Application for a non-material amendment following a grant of planning permission.

Number	
Suffix	
Property name	Land Adjacent 1
Address line 1	Orchard Way
Address line 2	Fontwell
Address line 3	
Town/city	Arundel
Postcode	BN18 0SH
Description of site location must be completed if postcode is not known:	
Easting (x)	495333
Northing (y)	107193

Non-material amenment following the grant of reference WA/18/19/PL for enlargement of front door canopy; external expression of chimney; variation of size & configuration of windows; omission of cladding to external elevations; variation of locations of brick & render to external elevations and brick plinth extended to whole of base.
Land adjacent to 1 Orchard Way Fontwell BN18 0SH

THE INSERTION OF A VELUX TYPE ROOFLIGHT ABOVE FIRST FLOOR HEAD HEIGHT, WITHIN ATTIC TO UNIT ONE

elevations:units one+two
approved: WA/107/19/NMA

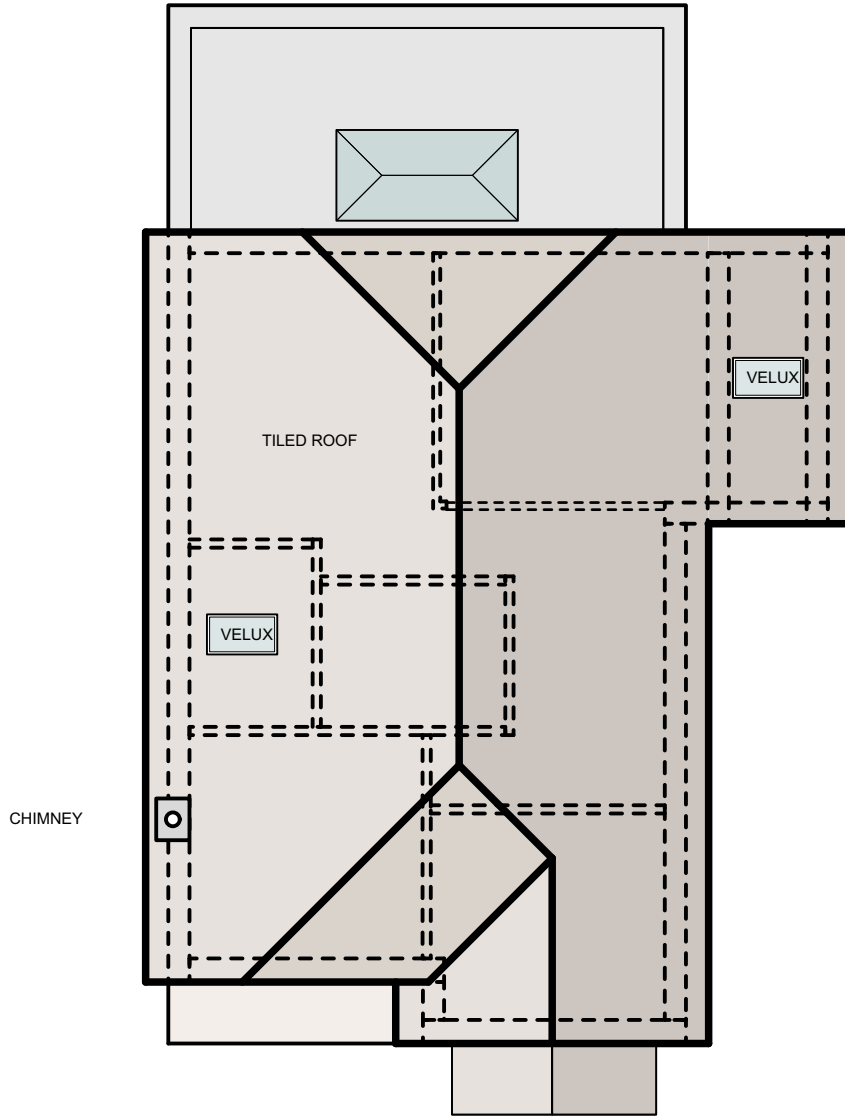
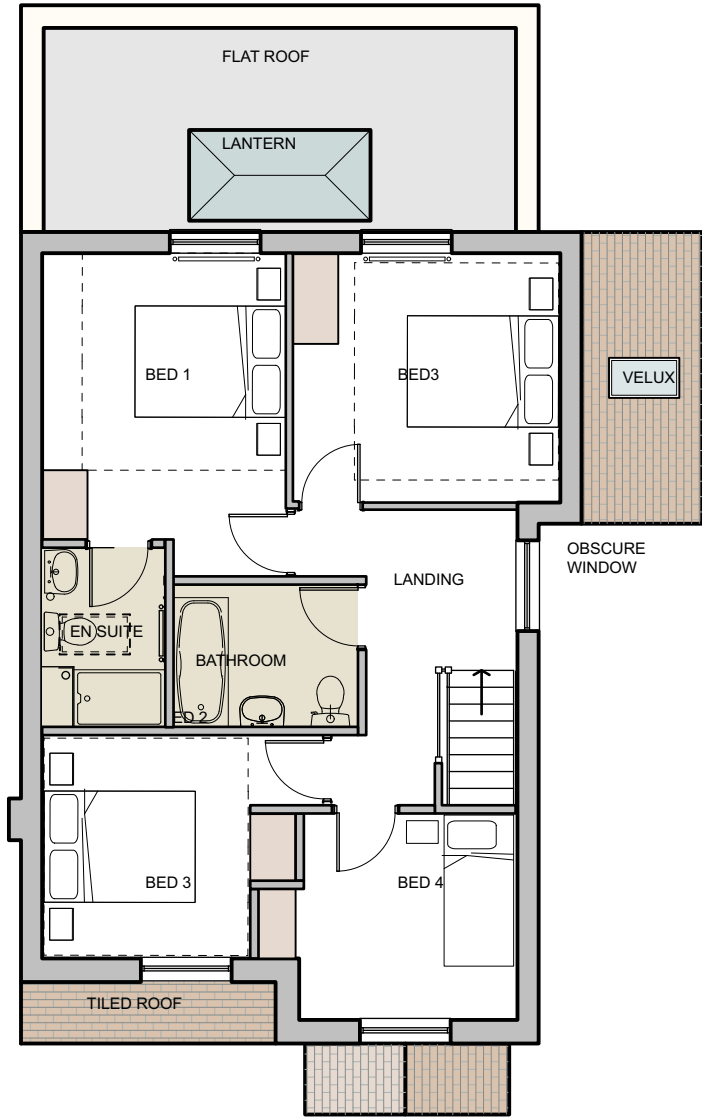
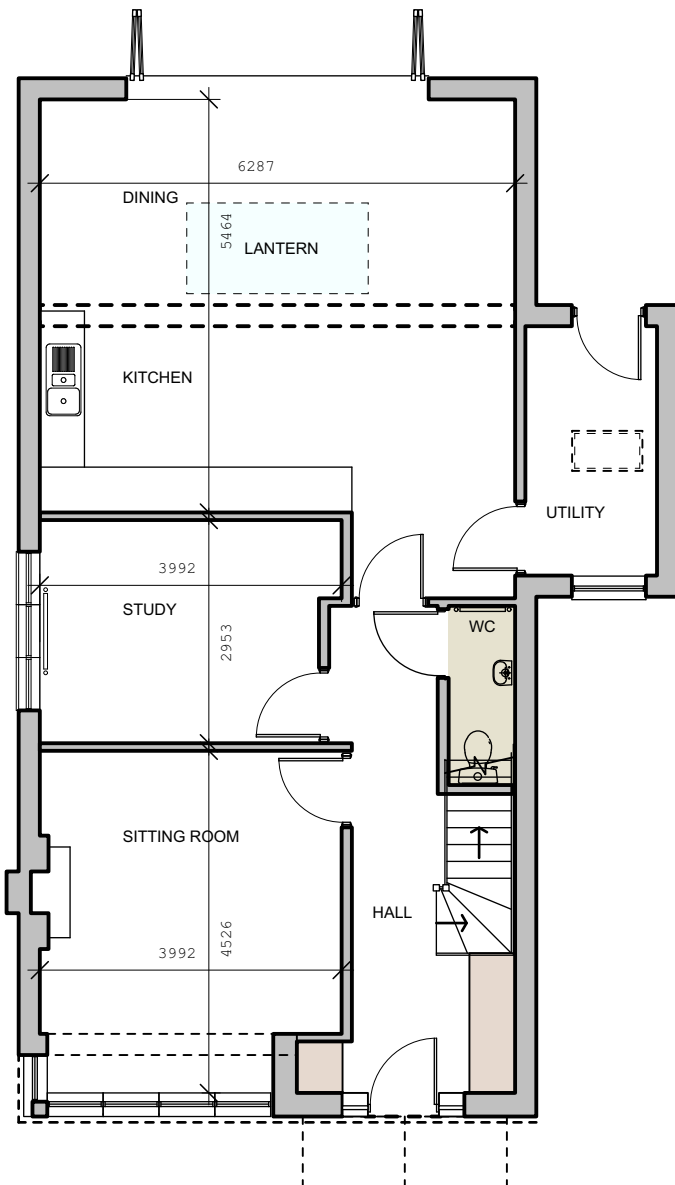
TO PROVIDE NATURAL DAYLIGHT TO AN INTERNAL BATHROOM
